ENG-CDR21013-R4-CDs.pdf Markup Summary

WINGWALL N1 PLAN
1"=10'

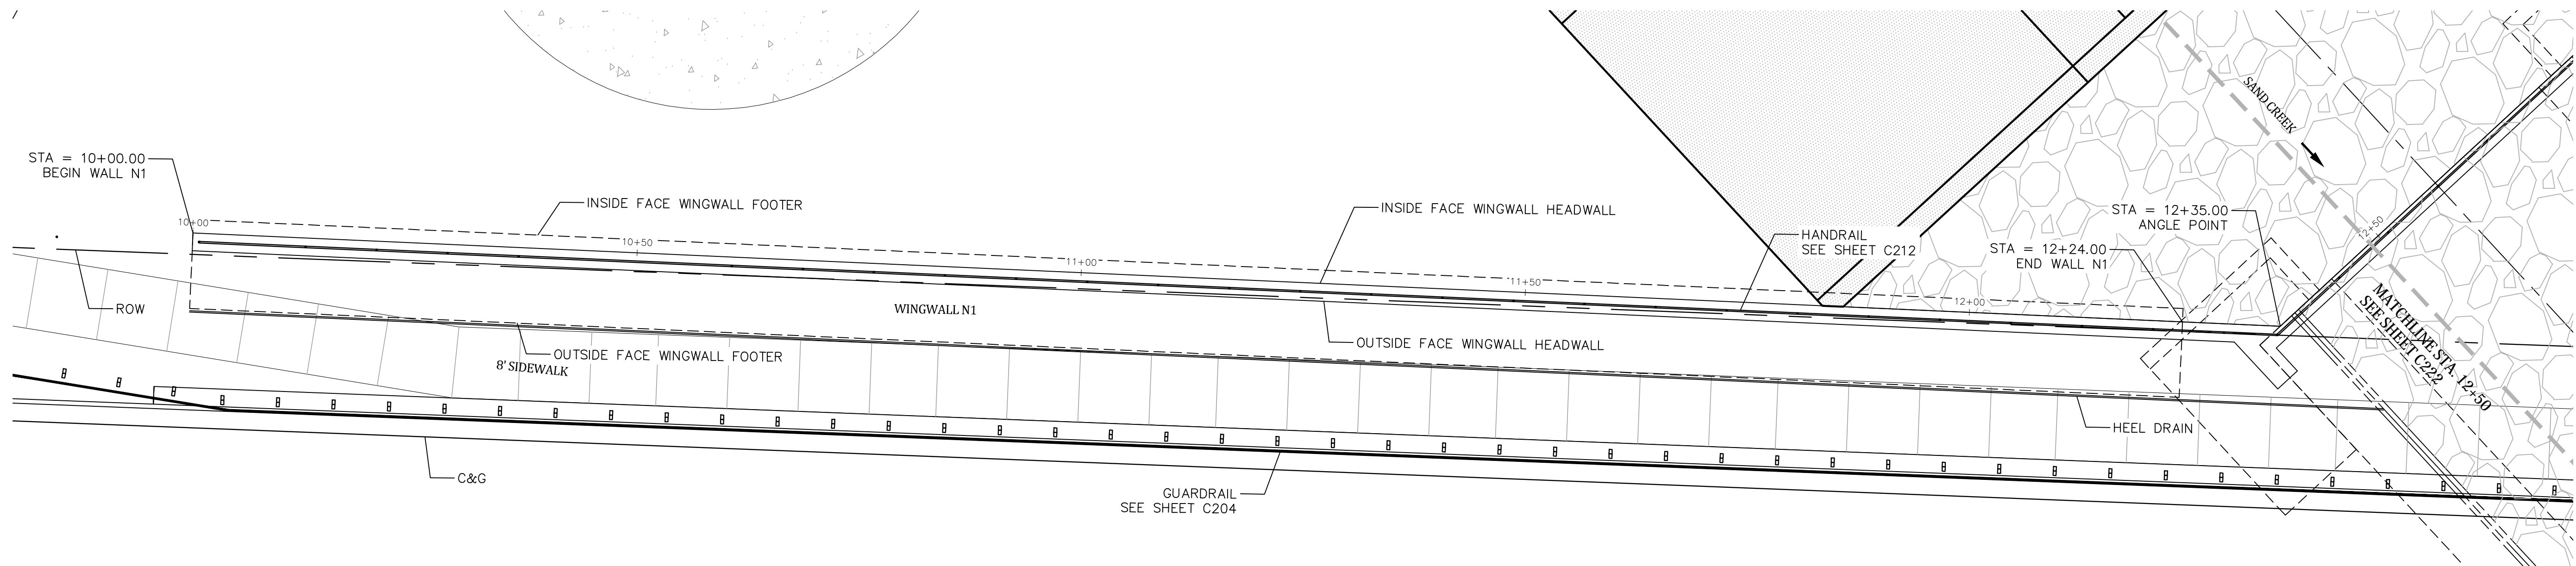
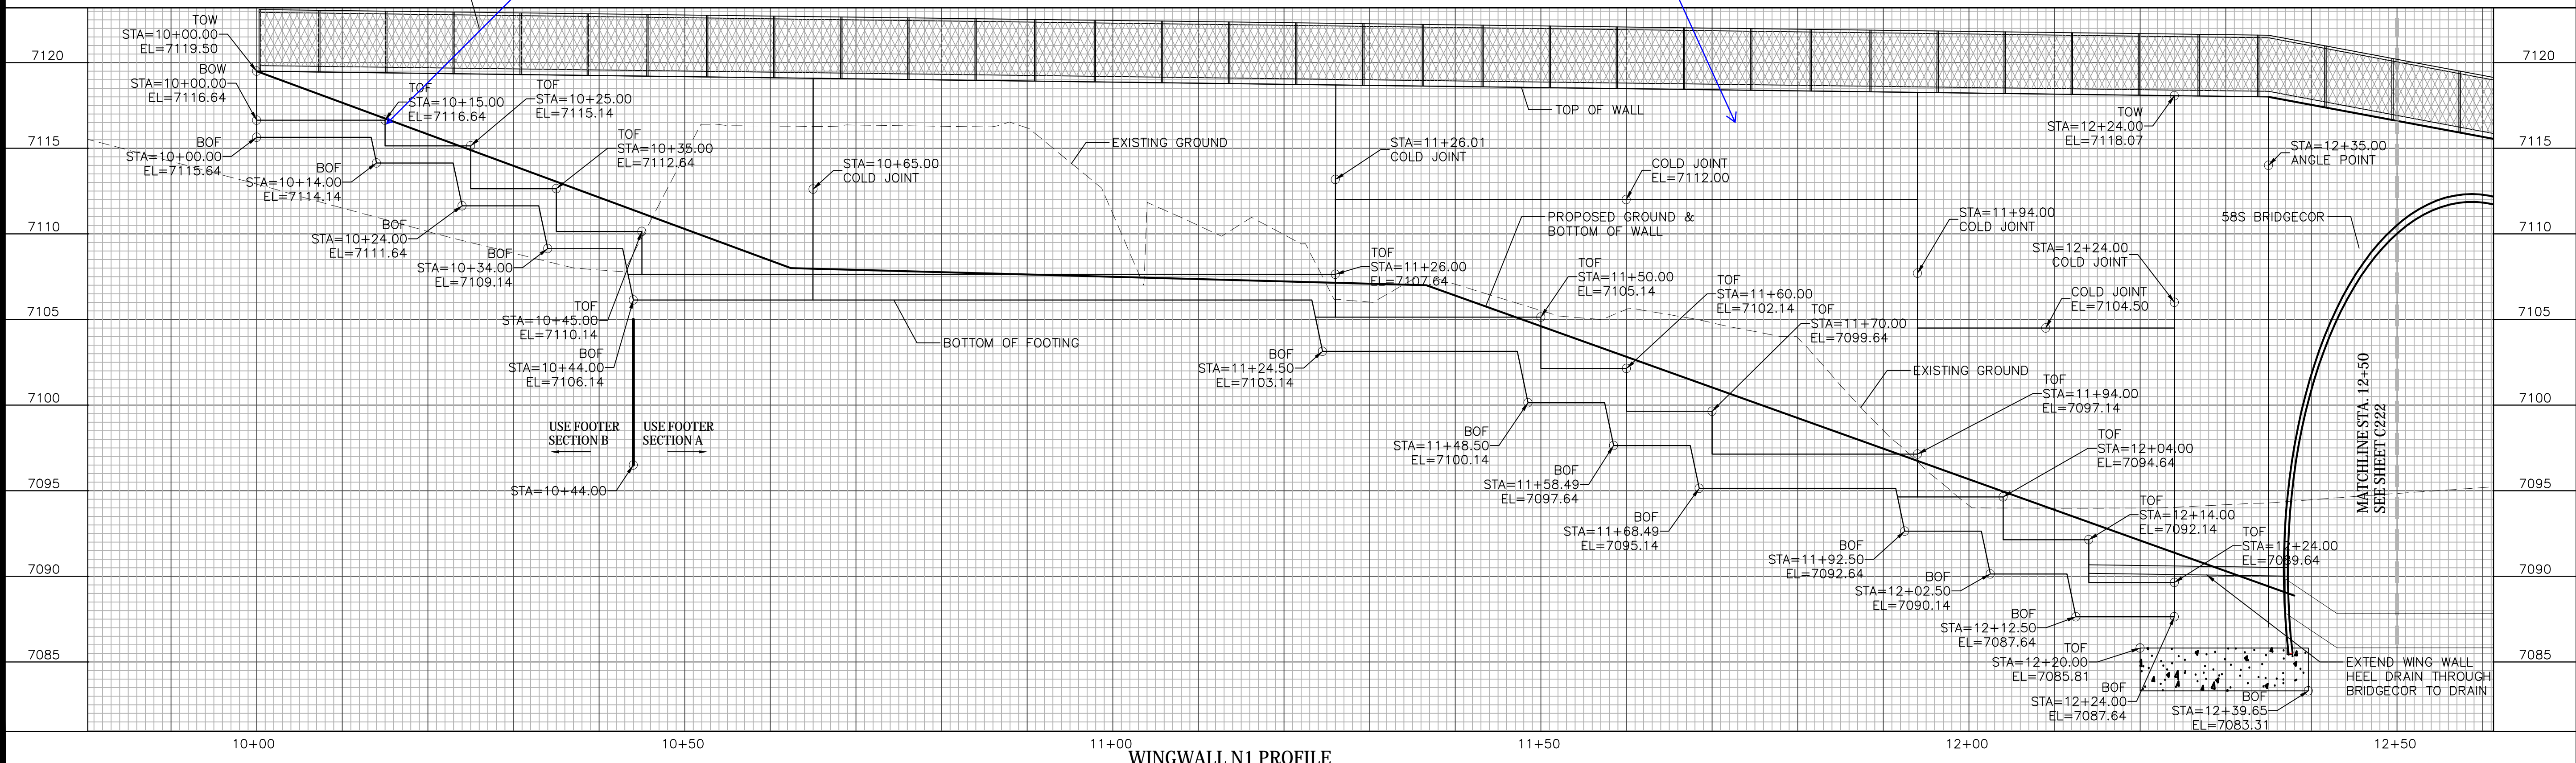
Please lighten the grid

C222

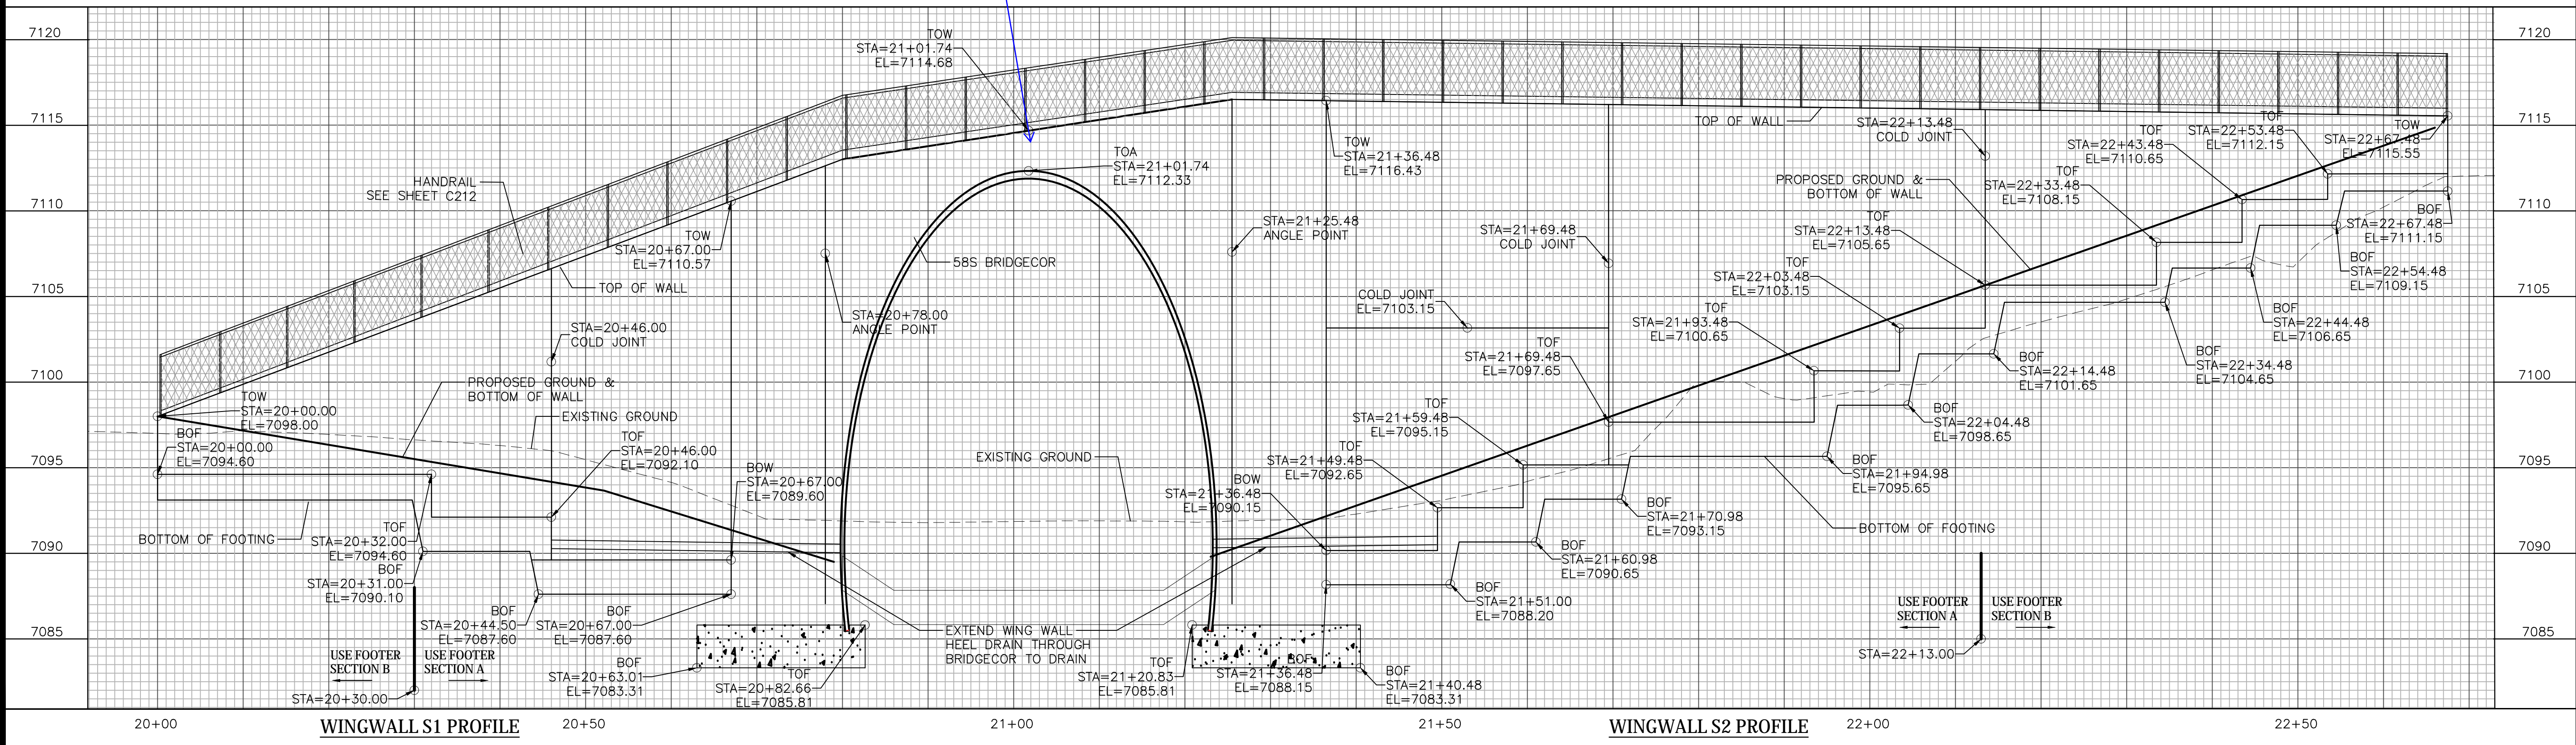
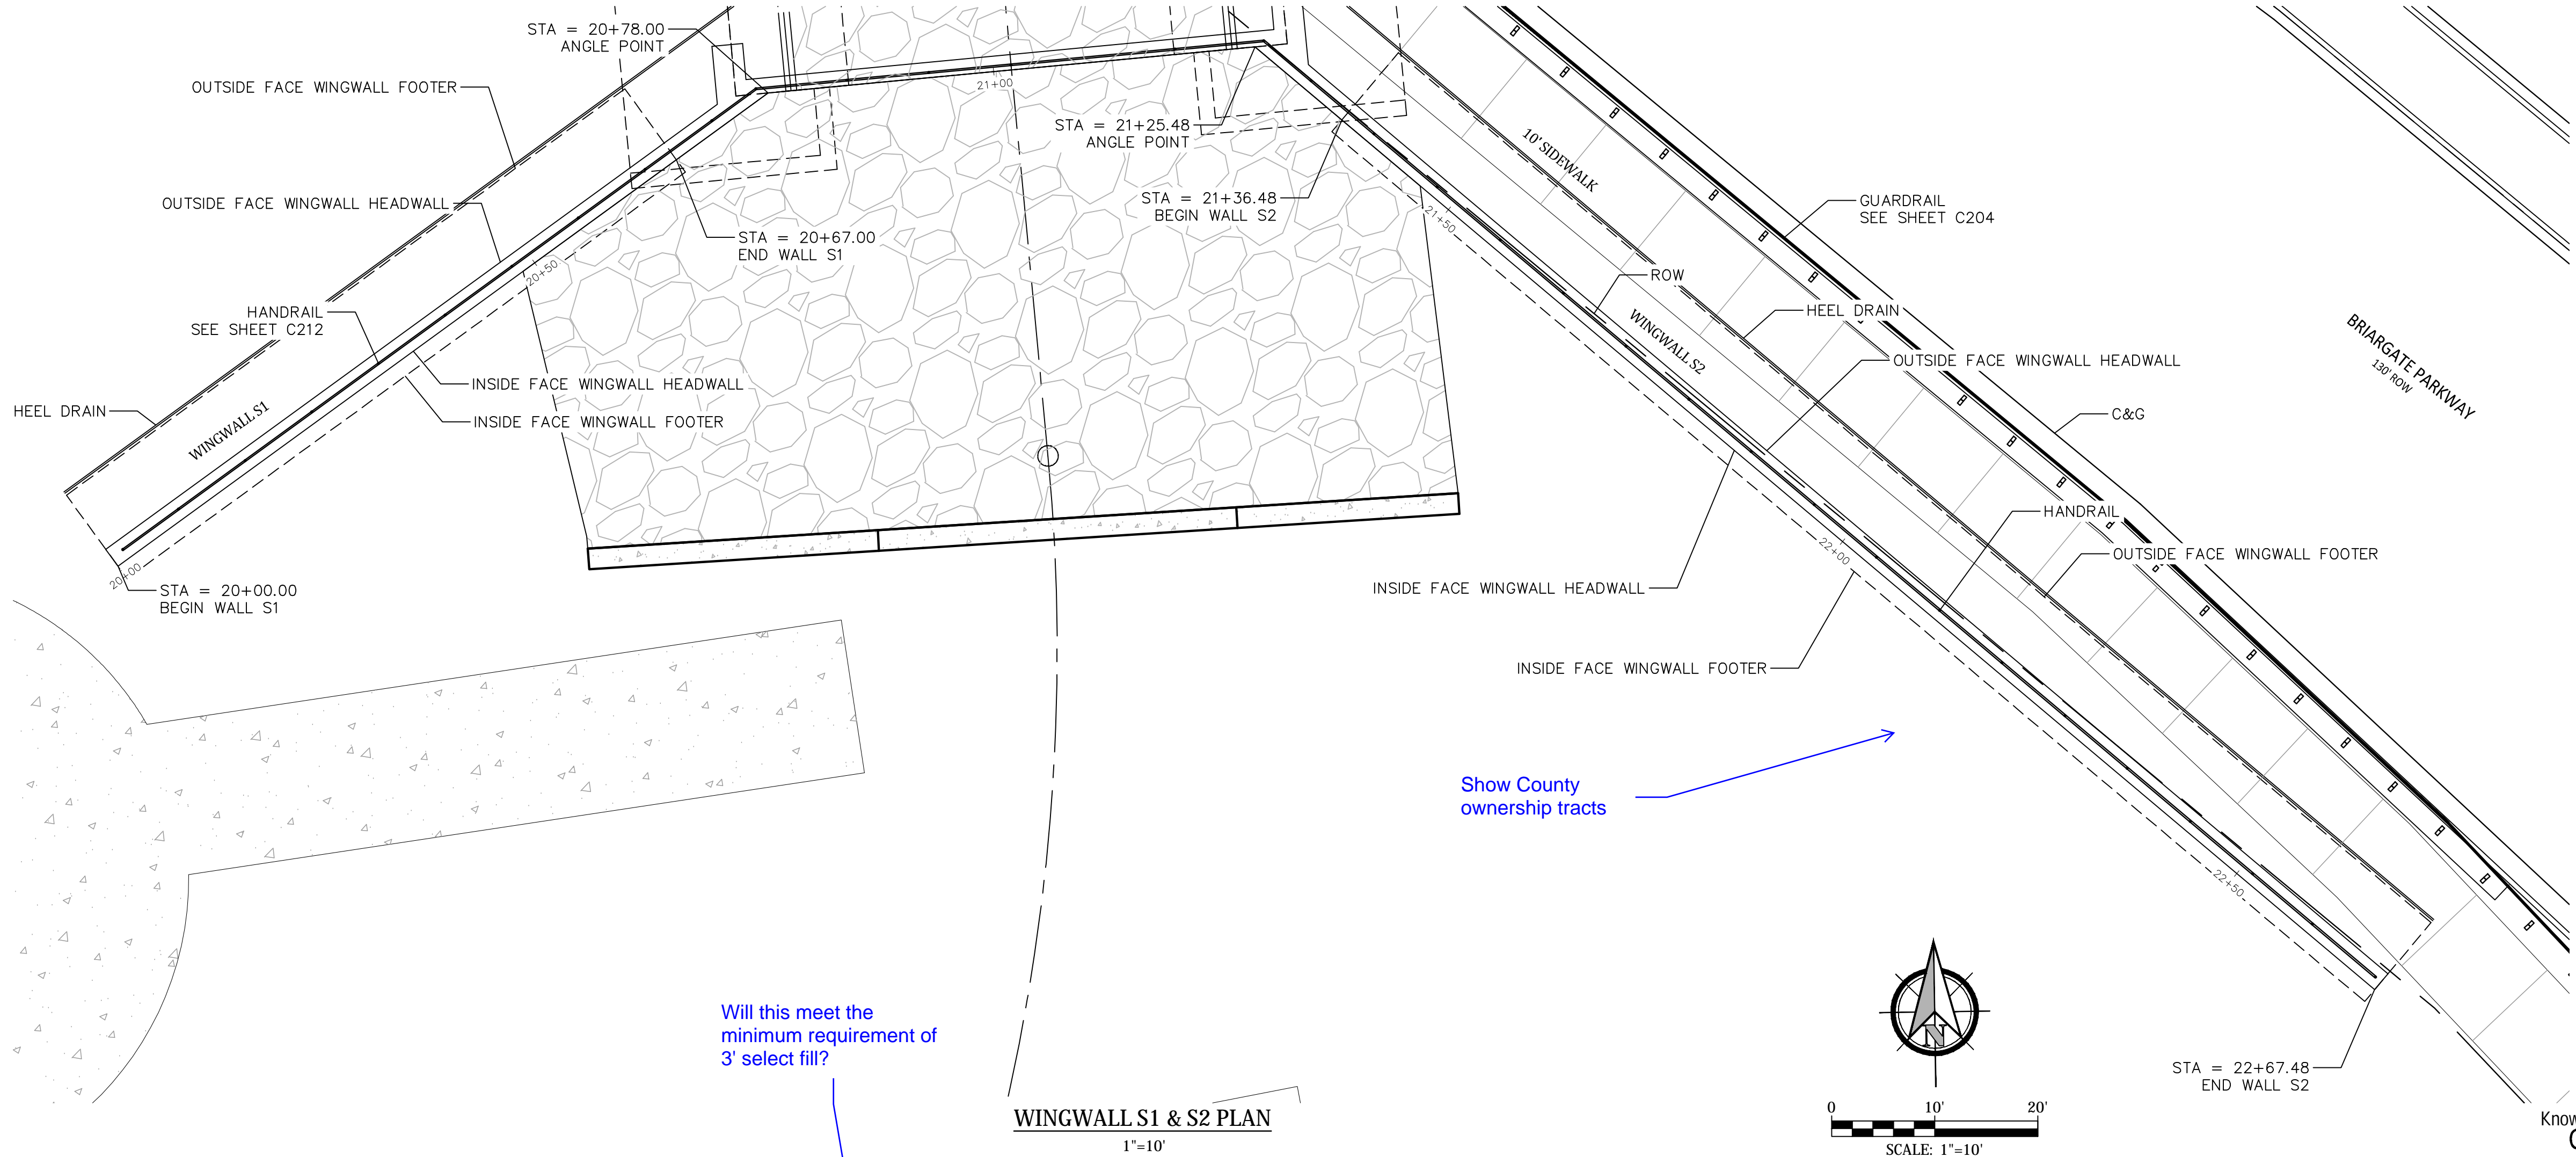
Will this meet the minimum requirement of 3' select fill?
